**RESPONSE TO ISSUES RAISED BY NSW DEPARTMENT OF PLANNING PURSUANT TO S75H(6)
OF THE ENVIRONMENTAL PLANNING & ASSESSMENT ACT 1979
LOT 11 DP 1104789 AND PART LOT 72 DP 1073600 DOLPHIN POINT
MAJOR PROJECT MP05_0016**

A meeting was held to discuss comments by the Department of Planning (DoP) in relation to concerns with the application on 14 January 2008. This meeting followed the issue of a letter containing agency responses issued by DoP on 8 January 2008. Agreements were reached (using the same numbering as contained in the letter of 8 January) regarding all matters. Following is a list of issues, the relevant agreement, the response from the proponent AND A COMMITMENT from the proponent where such is relevant.

REF. No. U11840M	
U11840M SHEET4.DWG	
ISSUE B	
SHEET	4 OF 4 SHEETS

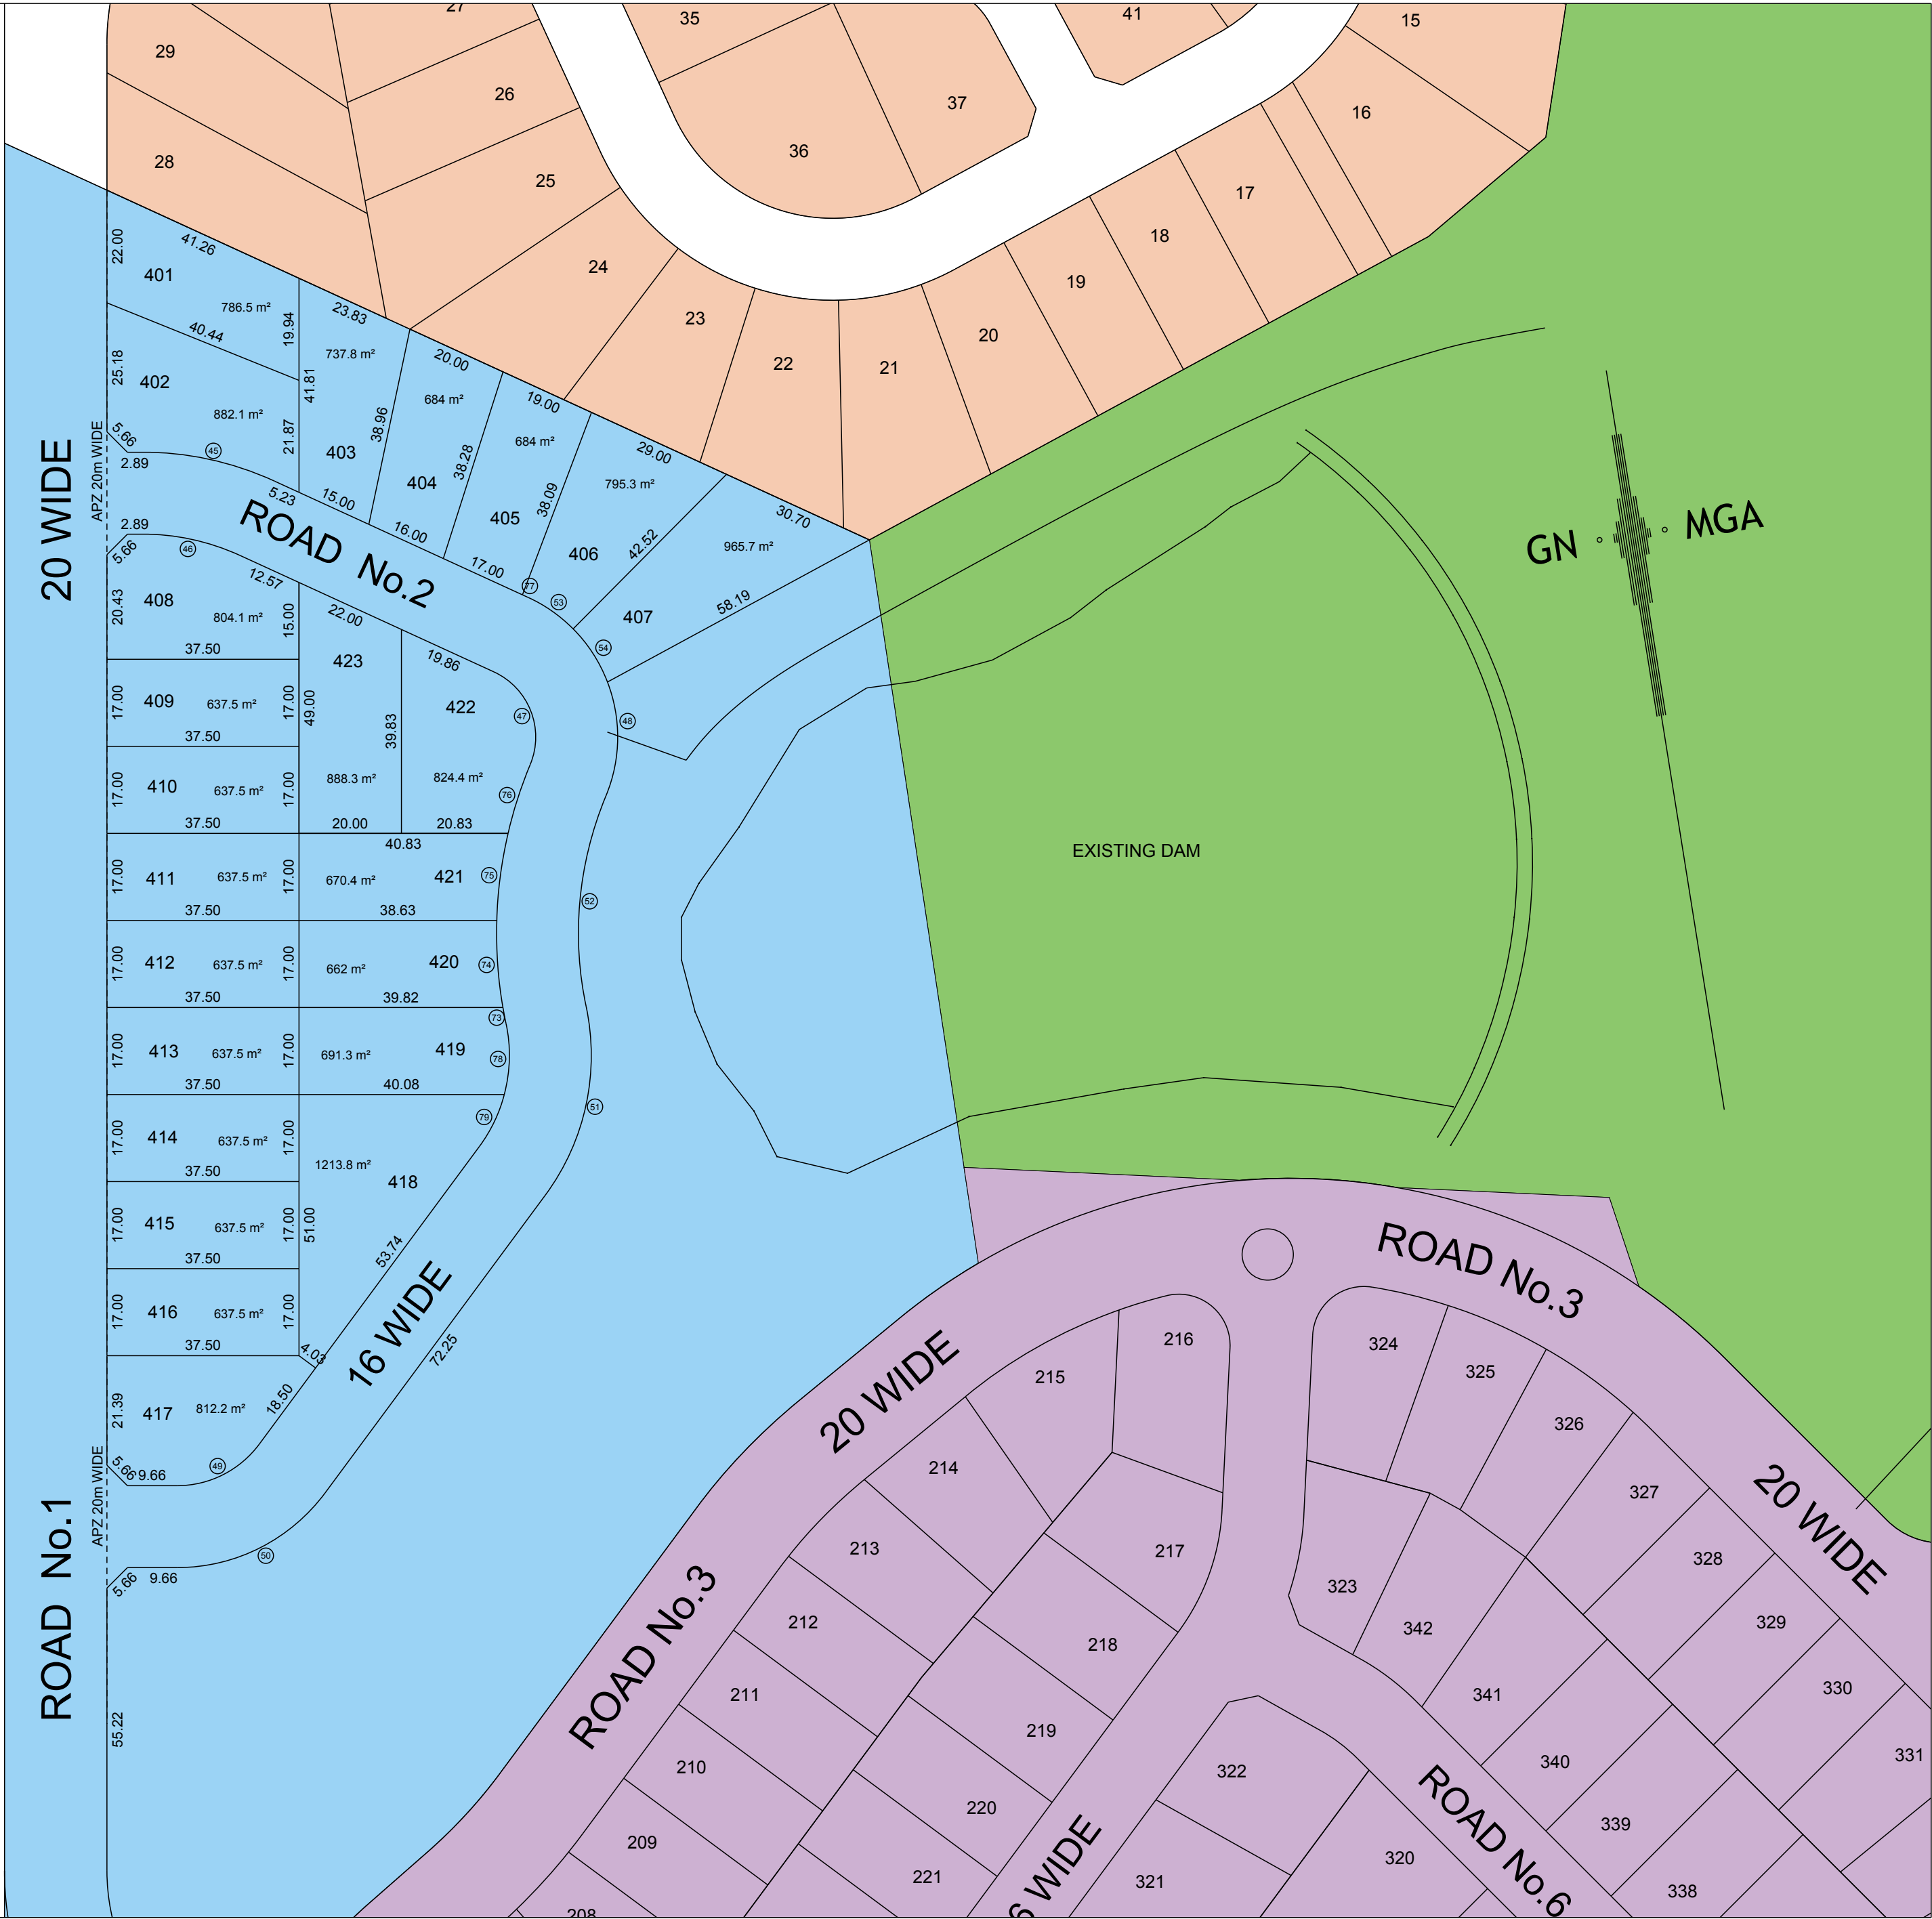
1.	<p><u>Issue</u></p> <p>The riparian corridor surrounding the western creek running between Stages 2 and 3 should be widened to include 20m of riparian vegetation and an additional 10m of buffer vegetation on both sides of the creek bank, extending to the edge of the water quality/detention pond. Amendments to the plans should be provided in this regard, showing the location of the creek bank and the two riparian zones (ie primary and buffer).</p> <p><u>Agreement</u></p> <p>Applicant agreed to amend plans in accordance with the above DWE request.</p> <p><u>Response</u></p> <p>The riparian corridor has been widened as requested. Plans showing amendments to the riparian corridor between Stages 2 and 3 are submitted herewith.</p>

3.	<p><u>Issue</u></p> <p>Accordingly, the plans should be amended to show the northern perimeter road to Stage 2 being relocated to be wholly clear of the riparian zones and the proposed 7(d2) zoning.</p> <p><u>Agreement</u></p> <p>Applicant agreed to amend plans in accordance with the above request.</p> <p><u>Response</u></p>

5.	<p><u>Issue</u></p> <p>The plans should be amended to show only one road (the collector road) crossing the western creek, and the crossing should be located to be perpendicular to the creekline and at an appropriate position to minimise impacts on the creek and the riparian corridor.</p> <p><u>Agreement</u></p> <p>Applicant agreed to amend plans in accordance with the above request. A sketch plan was produced and showed the road amended appropriately. It was discussed that the road should be located so as to avoid removal of the trees in the riparian corridor (which should be possible given there are only a few trees there).</p> <p><u>Response</u></p> <p>A redesign of the subdivision has been undertaken to effect this requirement. Refer to plans submitted herewith.</p>

6.	<p><u>Issue</u></p> <p>The plans should be amended such that no roads or residential allotments cross, or are within the 20m riparian buffer zone of the eastern creek (other than one crossing for the future collector road connection with the adjoining land to the east), and the crossing should be located to be perpendicular to the creekline and at an appropriate position to minimise impacts on the creek and the riparian corridor (see also comments in relation to point 8 below).</p> <p><u>Agreement</u></p> <p>Applicant agreed to amend plans in accordance with the above request subject to changes discussed to the offsets in point 4 above.</p> <p><u>Response</u></p>

<p>A redesign of the subdivision has been undertaken to effect this requirement. Refer to plans submitted herewith.</p>
7.	<p><u>Issue</u></p> <p>The locations of the Asset Protection Zones (APZs) are to be reconsidered to provide them wholly clear of the primary and buffer riparian zones for both creeks.</p> <p><u>Agreement</u></p> <p>Applicant agreed to amend plans in accordance with the above request, noting the APZ requirements of the 2006 guidelines are smaller. Applicant advised to provide an updated assessment of compliance of the amended plans with the whole of the 2006 guideline provisions.</p> <p><u>Response</u></p> <p>In consultation with the proponents bushfire consultant the subdivision has been amended to accord with APZ requirements as referred to in <i>Planning for Bushfire Protection 2006</i> (NSW Rural Fire Service). The APZs are wholly clear of primary and buffer riparian zones. Refer to plans submitted herewith.</p>

<p>The northern perimeter road for stage 2 has been relocated to be clear of riparian zone and 7(d2) zone in accordance with the plans submitted herewith.</p>

TYPICAL CROSS SECTION ROAD No.4

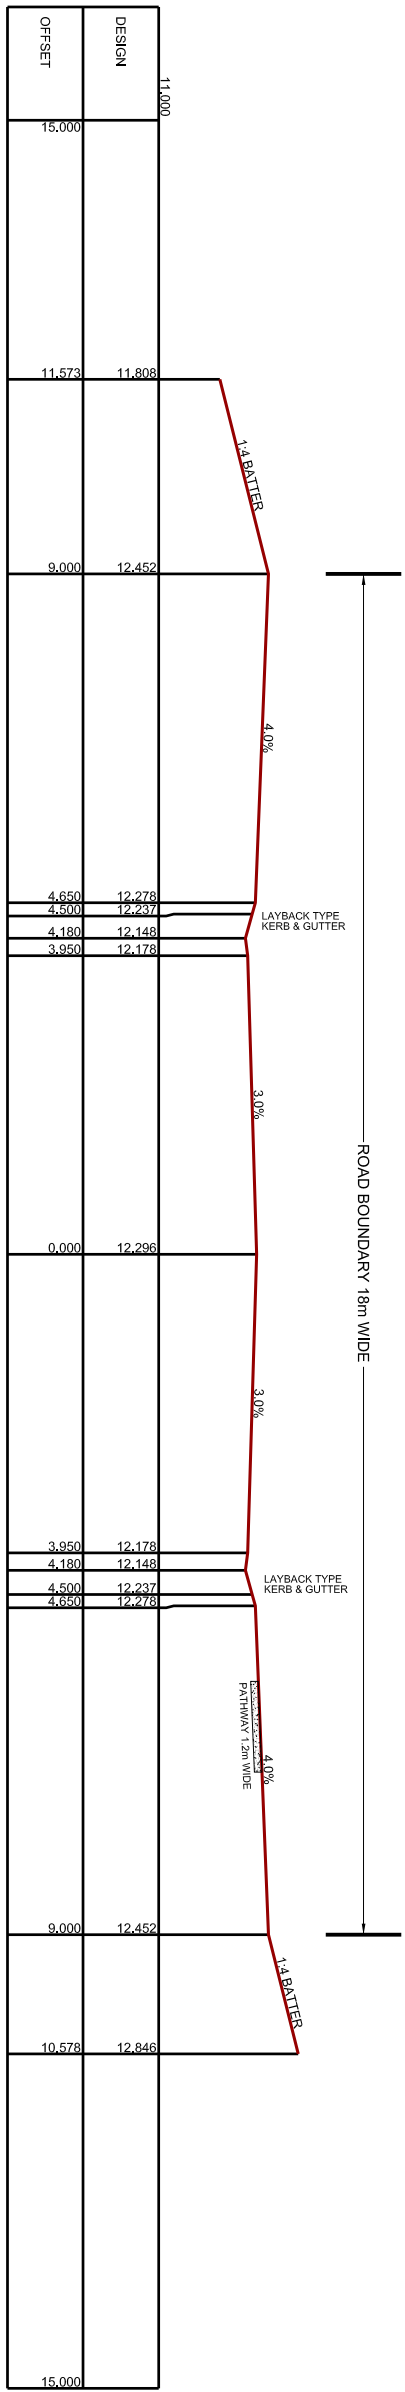
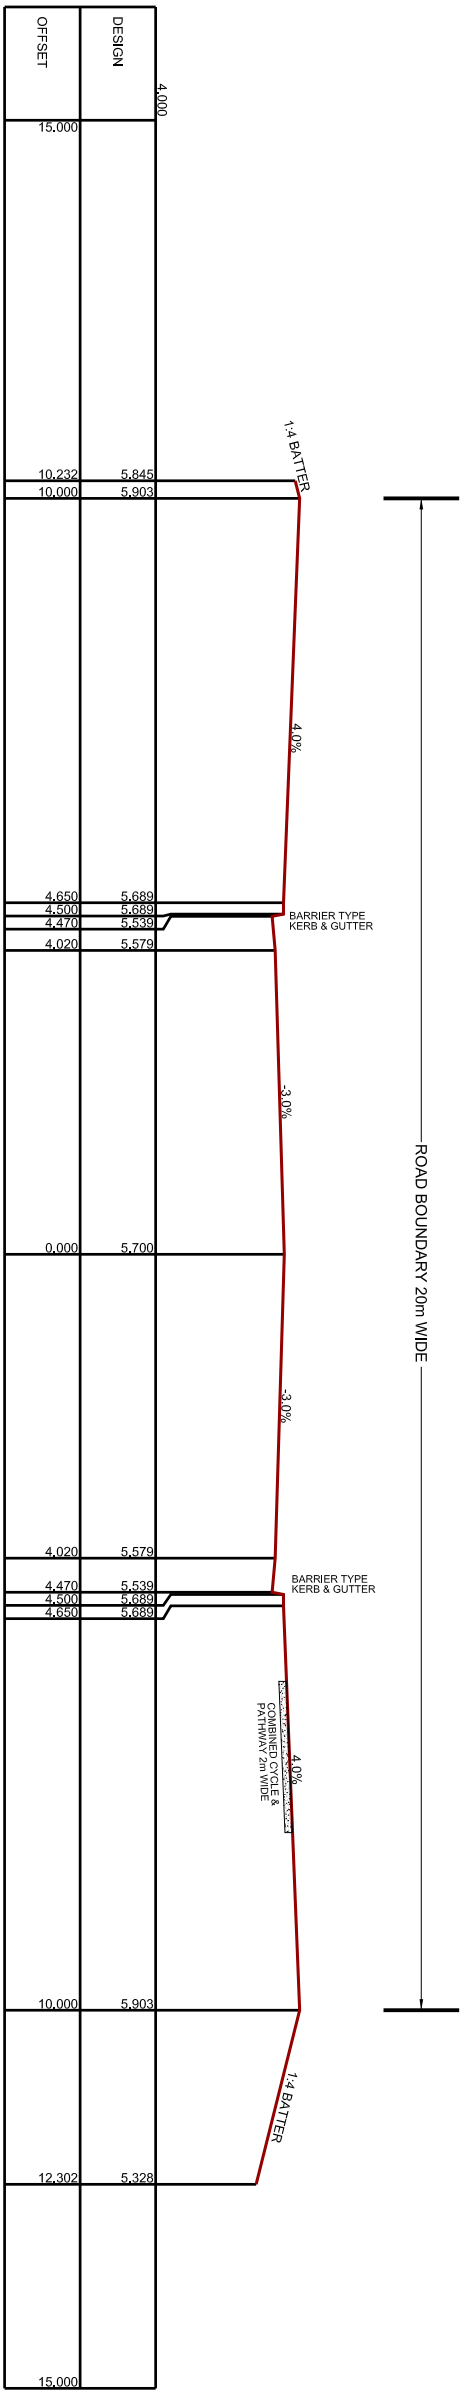
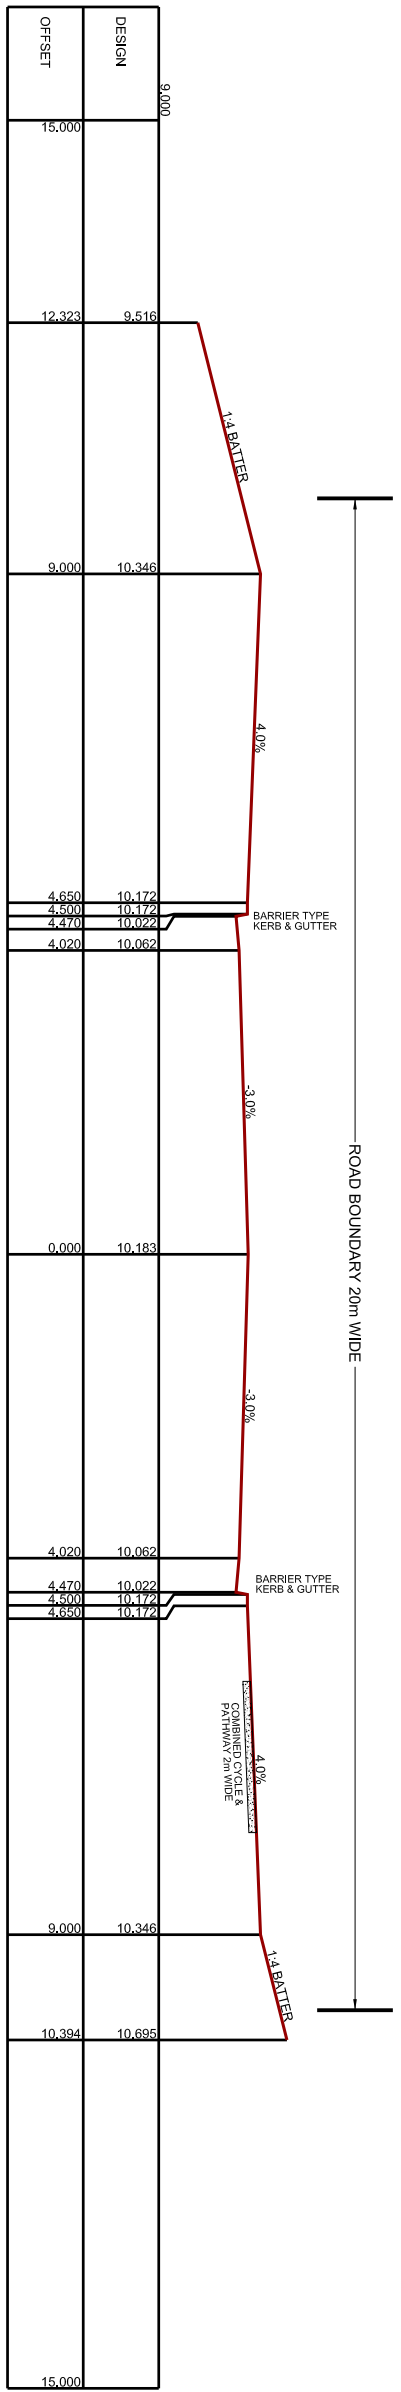
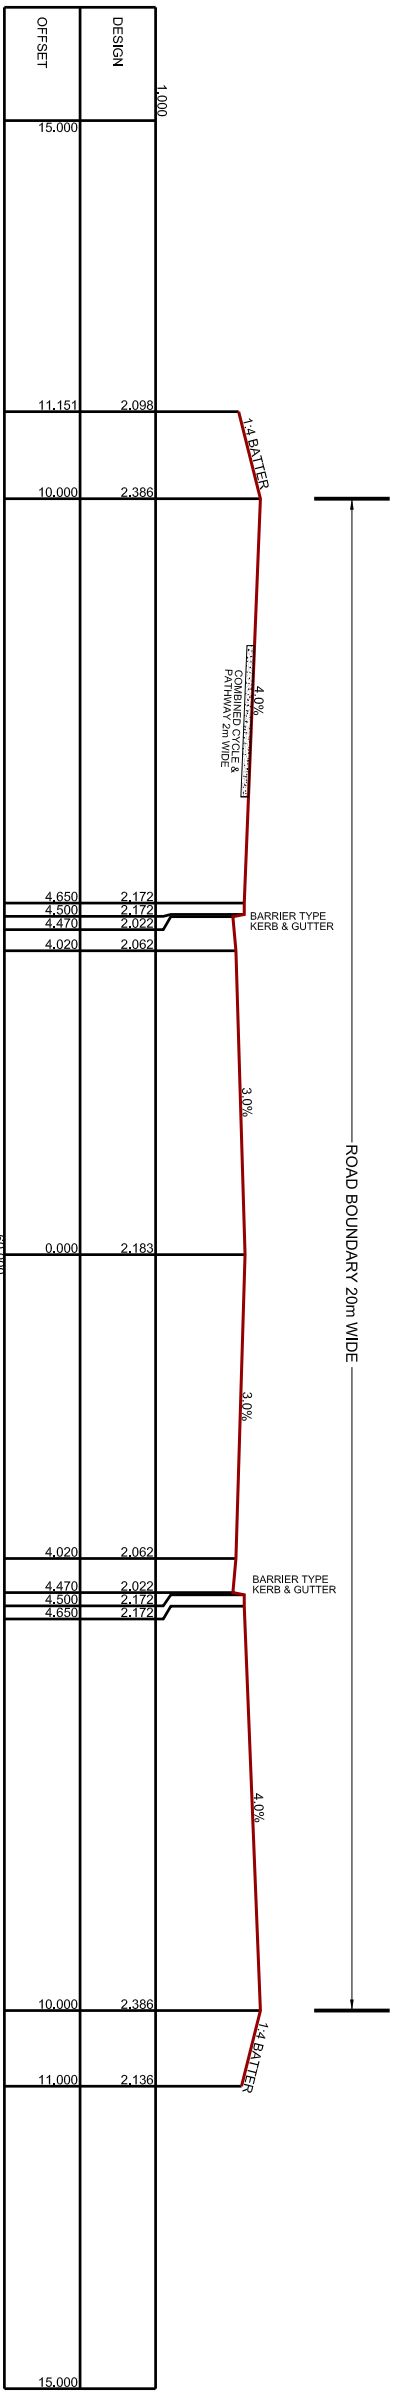
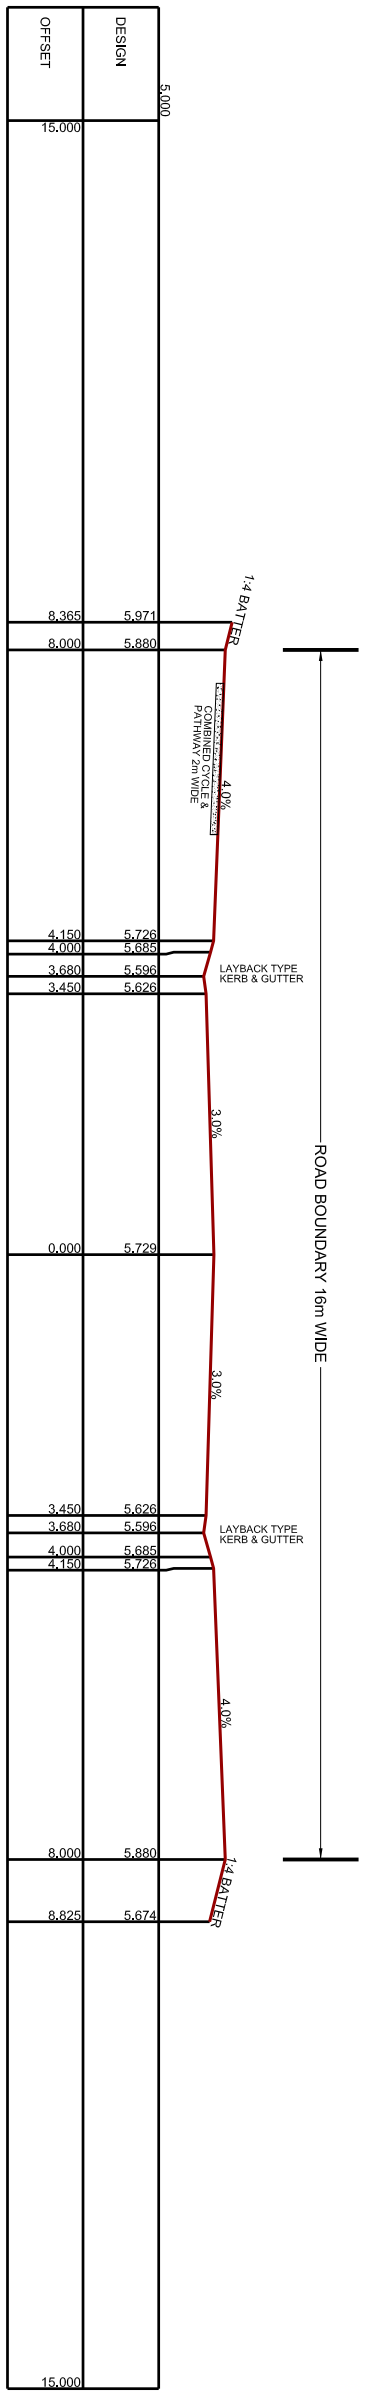
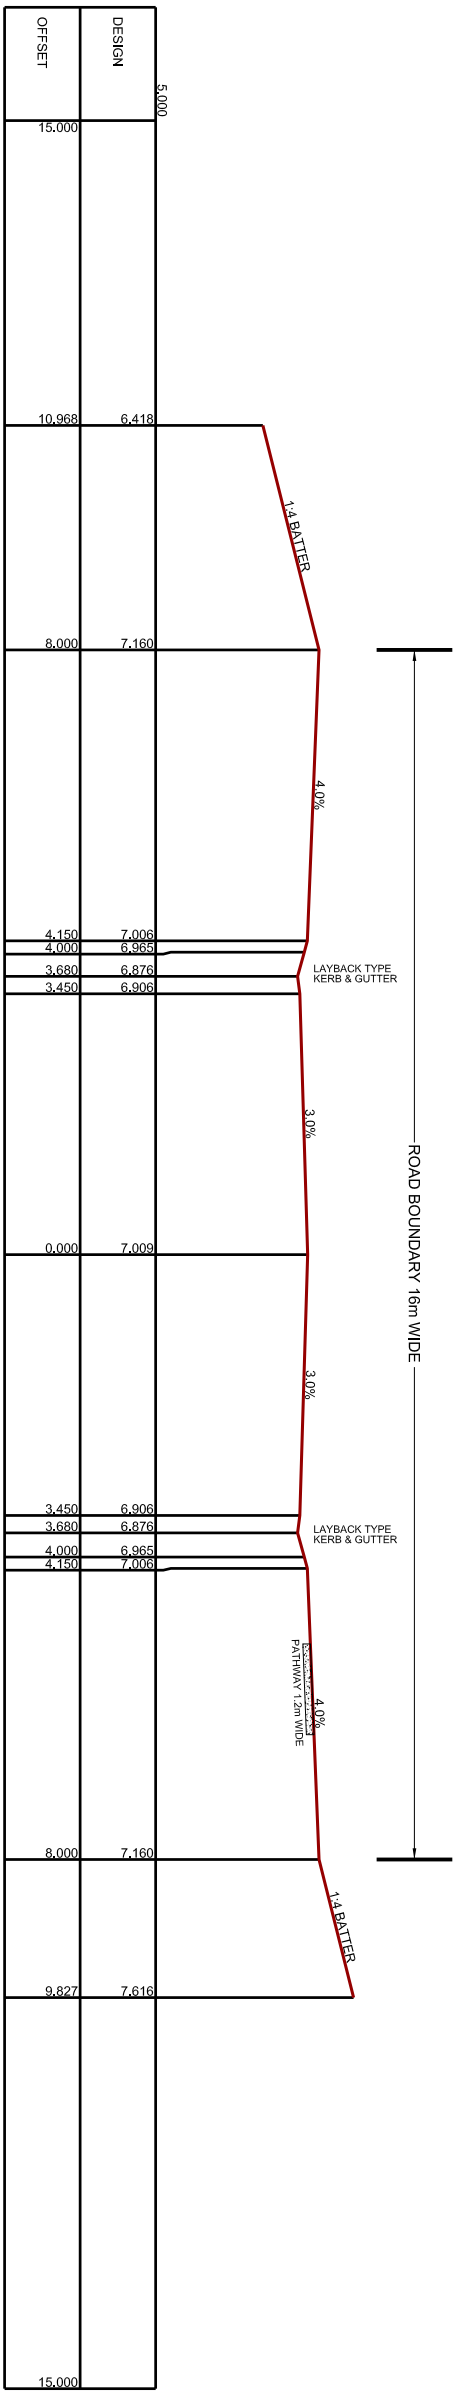
10.	<p><u>Issue</u></p> <p>Plans are to be provided for the proposed roads, to include a longsection and section and are to show the width of proposed gutter treatment, verges, paths and carriageways and are to detail any traffic control or design measures. The road designs are to ensure each road allows an appropriate speed of travel relative to its place in the hierarchy, that the collector road allows for appropriate movement of buses and that all roads are of appropriate design for access by large rigid vehicles (12.5m). The roads are to be designed to satisfy the requirements of Element RE8 of Shoalhaven DCP 100.</p>

<p><u>Agreement</u></p> <p>Applicant agreed to provide longsections once the road network was finalised. It was agreed that sections are not required for each road, but rather typical sections for each road type were to be provided detailing reserve, verge, carriageway and foot/cycle path widths, together with details of proposed guttering. It was advised that the designs (including intersections) should address the requirements of DCP 100 and the 2006 bushfire guidelines (where appropriate) and shall allow for movement of 12.5m rigid vehicles generally and 14.5m rigid vehicles along the collector route (and alternate bus loop discussed in point 25). It was advised that Council was seeking a roundabout (mountable) at the intersection of the north-south road (not the one to intersect with the collector connection to the adjoining site) with the east-west collector road on the site.</p> <p><u>Response</u></p> <p>Typical cross sections for roads have been provided. Refer plans submitted herewith. A roundabout (mountable) at the intersection of the north-south road in the vicinity of the existing dam has been provided.</p>
